From: Mark Warwick <Mark.Warwick@arun.gov.uk>
Sent: 31 October 2019 17:04
To: Raymond Cole <Raymond.Cole@arun.gov.uk>
Cc: Planning.Responses <Planning.Responses@arun.gov.uk>
Subject: AL/72/19/PL

Planning Application Ref: AL/72/19/PL

Location: Ryefields Farmhouse, Oak Tree Lane, Woodgate, PO20 3GU

Description of works: Demolition of existing buildings & erection of 10 No. houses, comprising 1x three bedroom detached, 6x three bedroom semi-detached & 3x four-bedroom detached houses with associated access & parking (resubmission following AL/118/18/OUT).

Tree Categories

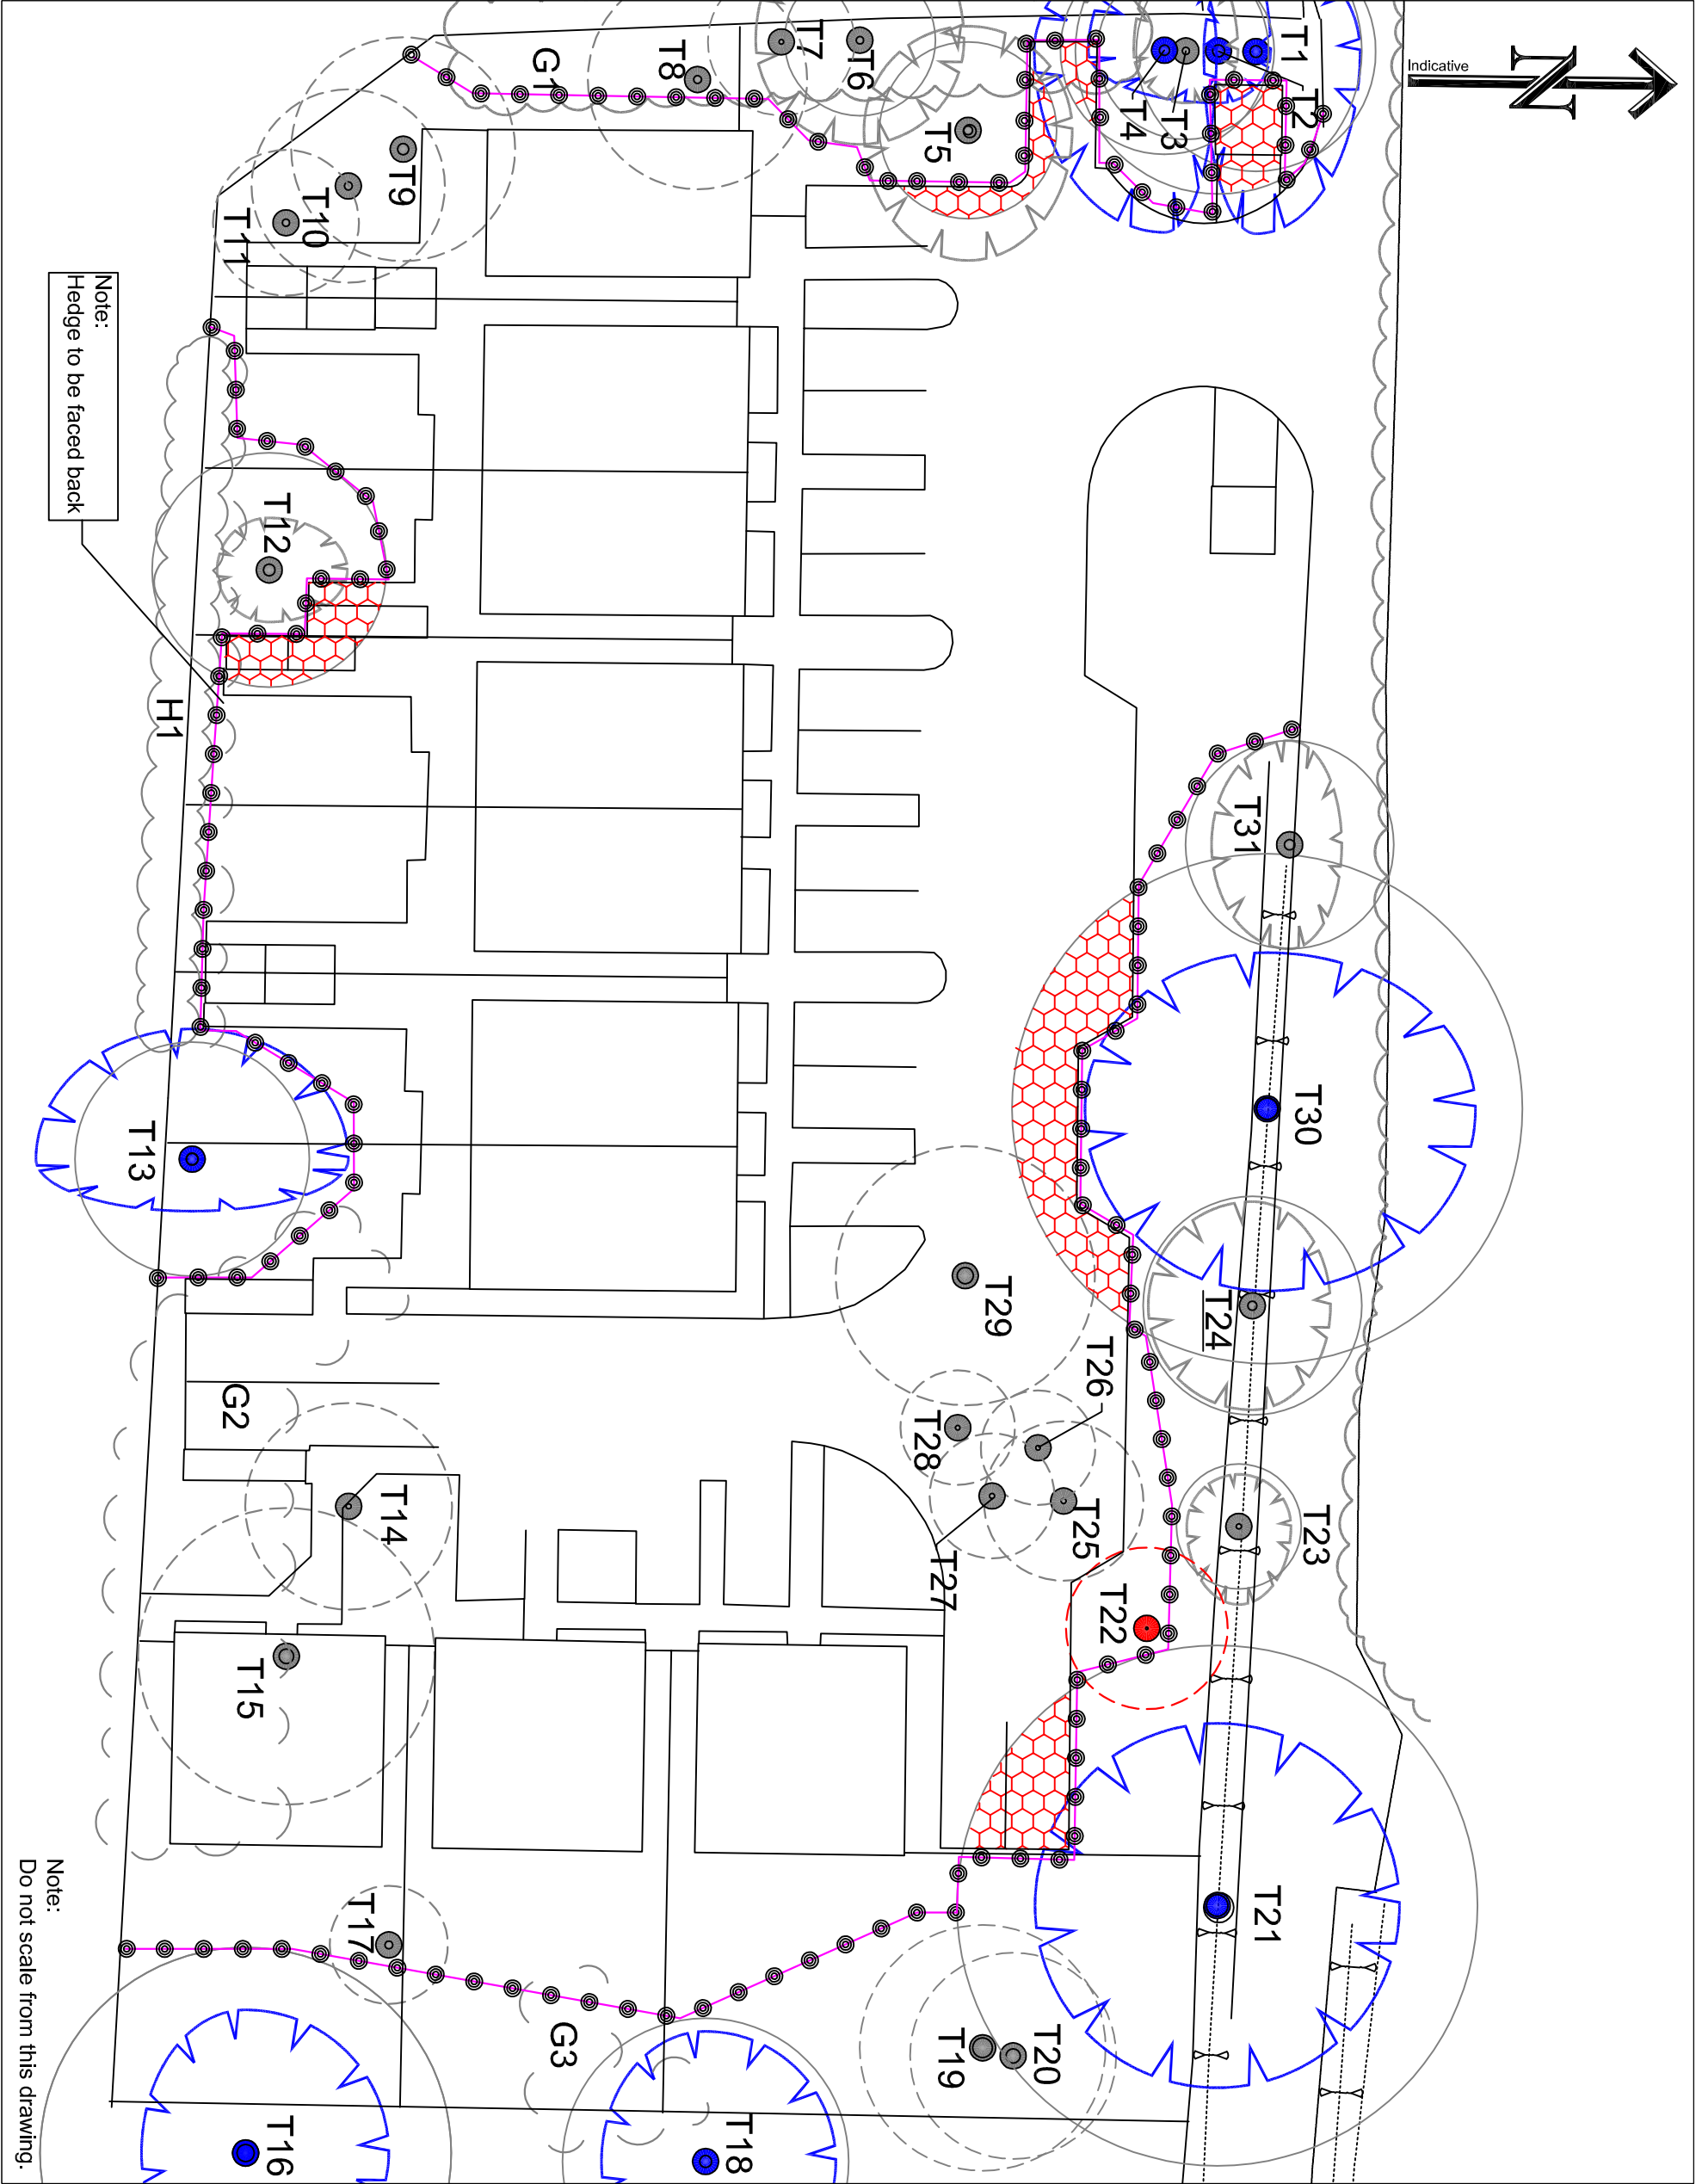
- The current proposed layout is going to impact on significant trees (T21 and T30) both above and below ground. Although achievable in principle by adopting the tree protection measures proposed; there is nonetheless a risk that attaches during such incursion of root protection areas. This is especially significant where the trees in question are by far the most important locally.

- The Tree Survey Report discusses Tree Protection in paragraph 5.5 (p8). It is stated that *'The fence will consist of "Heras" type panels or similar braced at appropriate intervals and secured to keep in place'*. For clarity, I would expect to see those panels mounted on a rigid scaffold framework supported by back-stays and vertical poles at appropriate intervals and driven a minimum 600mm into the ground – so as to be 'fit for purpose' (as per Figure 2, BS5837:2012, *Default specification for protective barrier*).

- I recommend the above scheme for **APPROVAL**, subject to the following conditions being applied:
 1. Before the site is occupied or any machinery is introduced to the site or demolition work or construction work or alterations to existing ground levels takes place a **PRE-COMMENCEMENT Site Meeting** is to take place between the Planning Authority's Tree Officer and the Arboricultural Expert representing the site owner(s) – at this meeting all protective fencing and ground protection measures will be inspected to verify they are 'Fit for Purpose' as required under British Standard 5837:2012 and have been erected and positioned exactly as shown on the **Tree Protection Plan, ref.18-668-TPP-B, 14.08.19, Canopy Consultancy**.

- When constructing the tree protection fencing, Heras panels must be mounted on a rigid scaffold framework supported by back-stays or vertical poles at appropriate intervals and driven a minimum 600mm into the ground – so as to be 'fit for purpose' (as per Figure 2, BS5837:2012, *Default specification for protective barrier*).
